**Consultation Response from KC,
Ecology Unit**

2026/92468 Carter Plantation Farm, Thick Hollins Road, Meltham, Holmfirth, HD9 3XD

Discharge of details reserved by conditions 6 (CEMP), 7 (HMMP) and 8 (Tree Protection Plan) on previous permission 2026/91078 for erection of agricultural building.

Date Responded: 17/09/2026

Habitat Retention Plan PM-F01

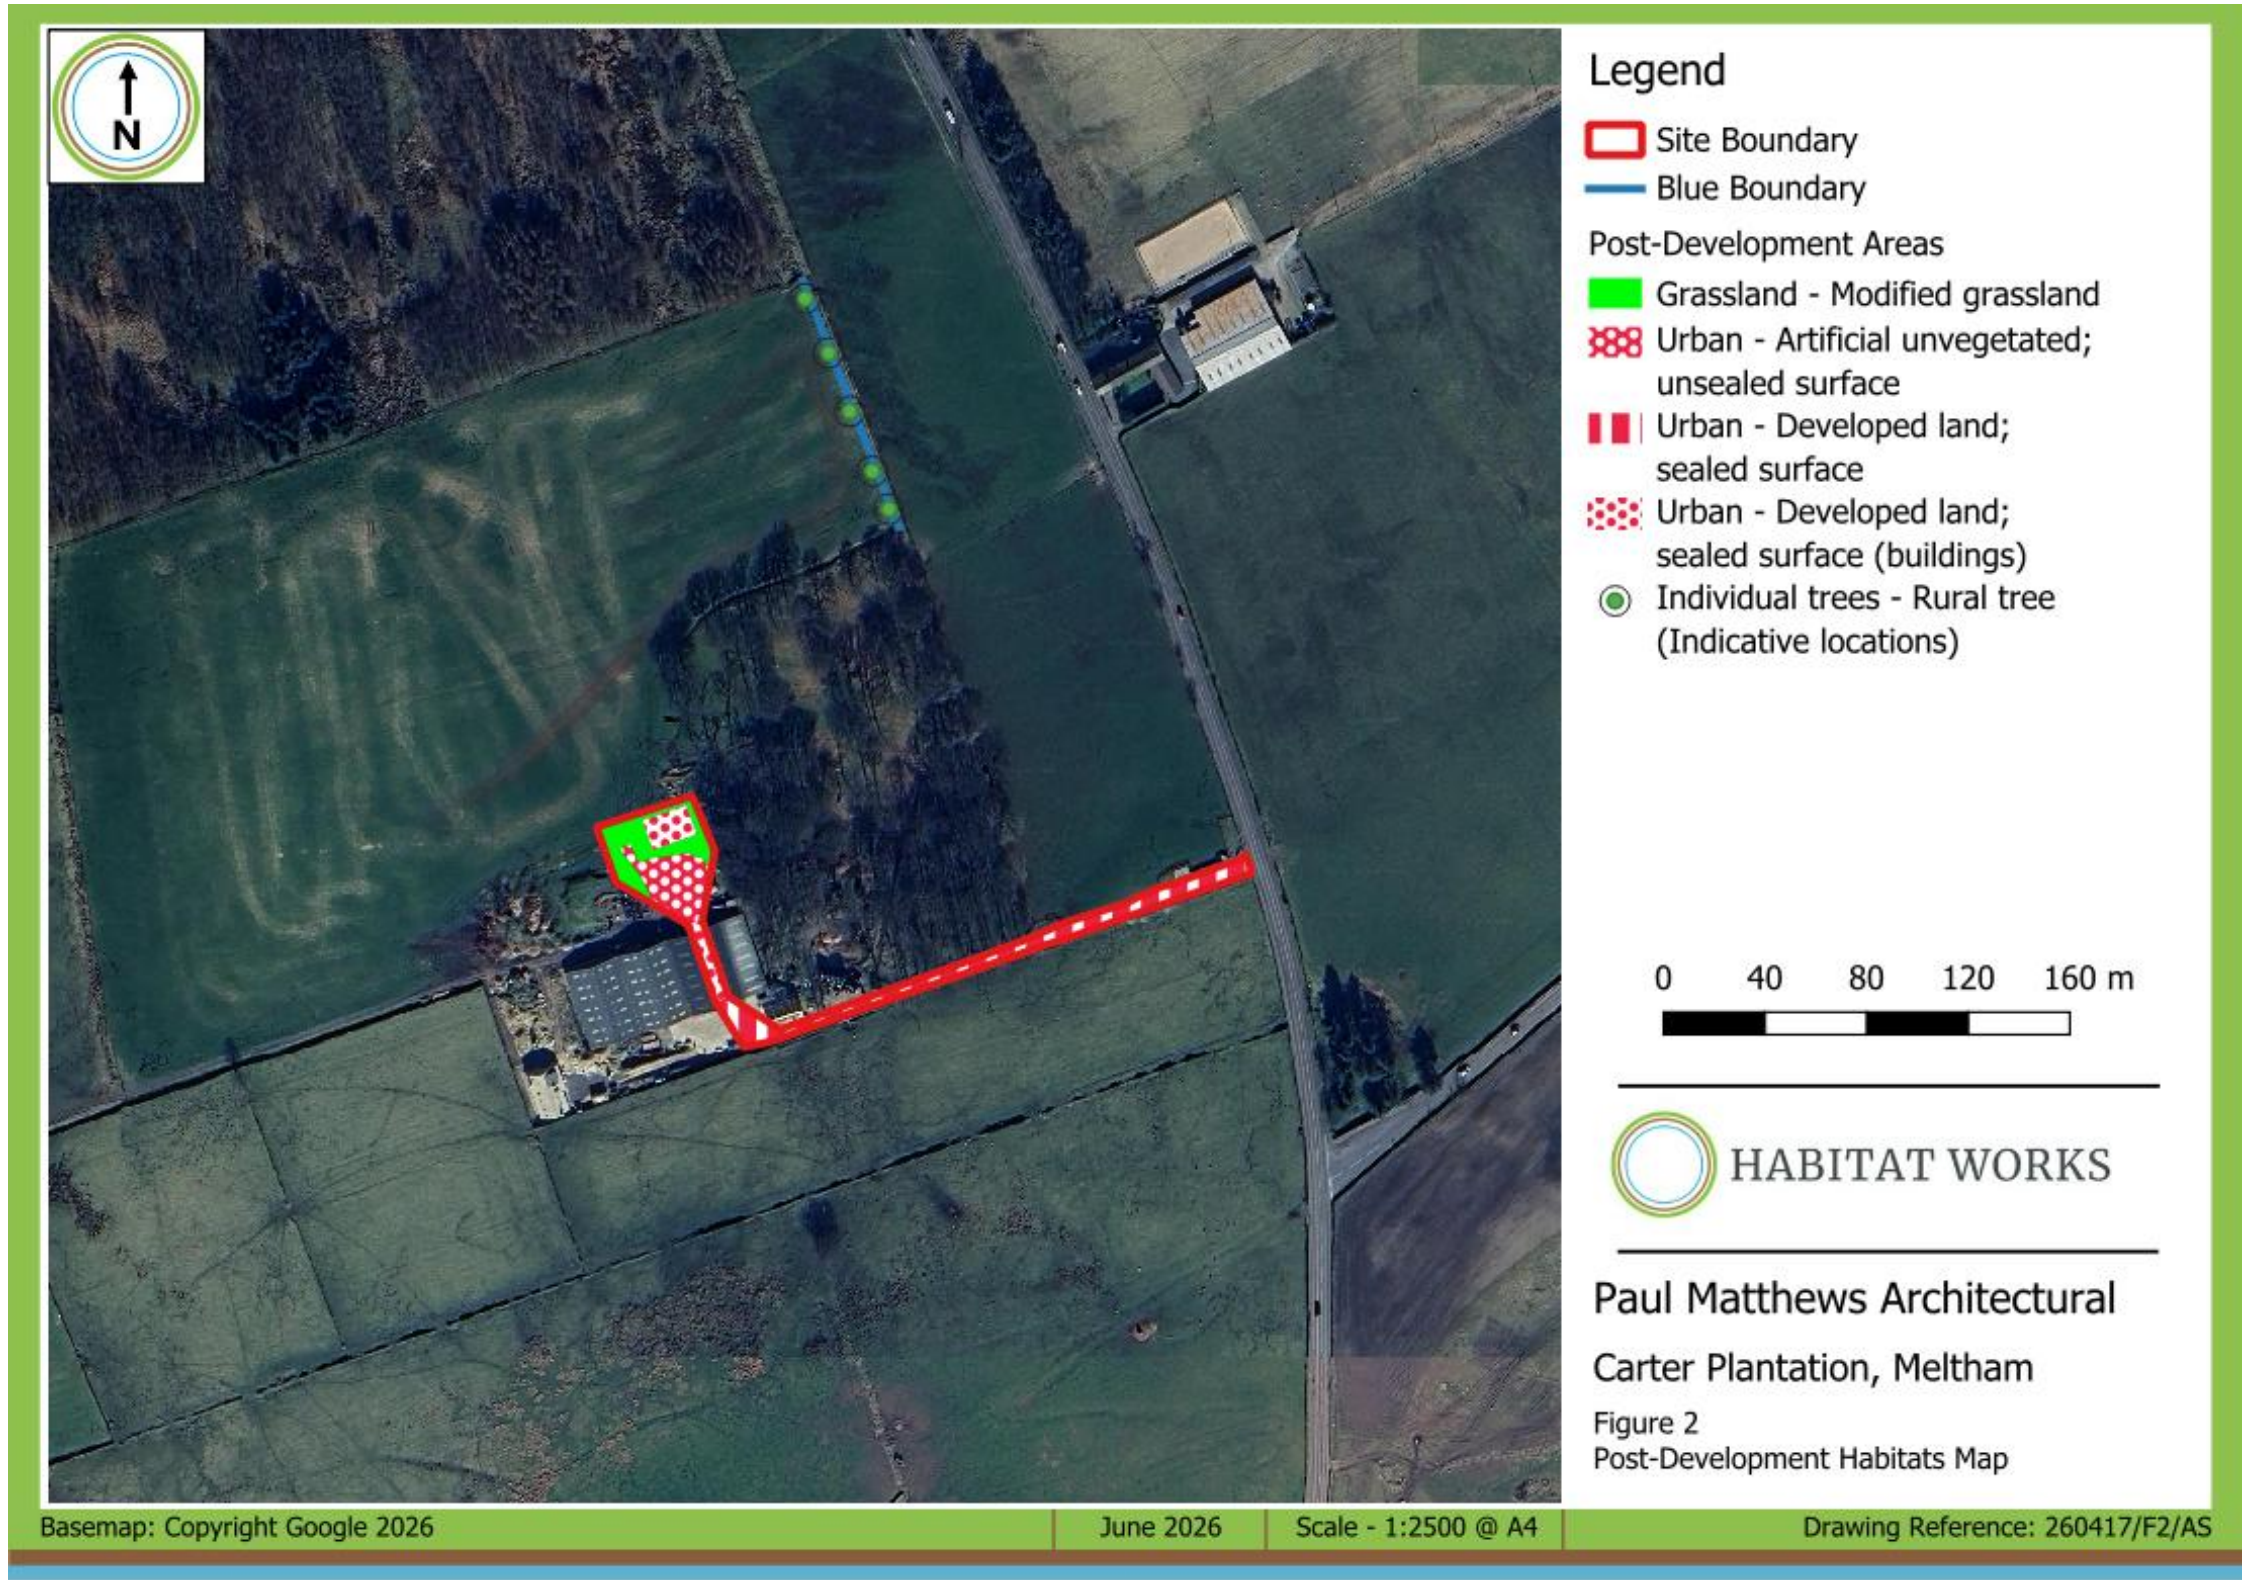
Condition 7 requires that the Habitat Management and Monitoring Plan prepared in accordance with the approved Biodiversity Net Gain Plan, but no approved Biodiversity Net Gain Plan has been submitted. This is a government template, similar to the Habitat Management and Monitoring Plan template, which should detail the Biodiversity Net Gain delivery of the site. From the documents it appears that the 'net gain' will be achieved through planted offsite land owned by the same landowner. As the Biodiversity Net Gain delivery is outside of the red line boundary, it will need to be secured via a legal agreement and registered on the Biodiversity Net Gain Sites register administered by NE. If the site proposals can be amended to deliver the planting within the red line boundary, no legal agreement will be required.
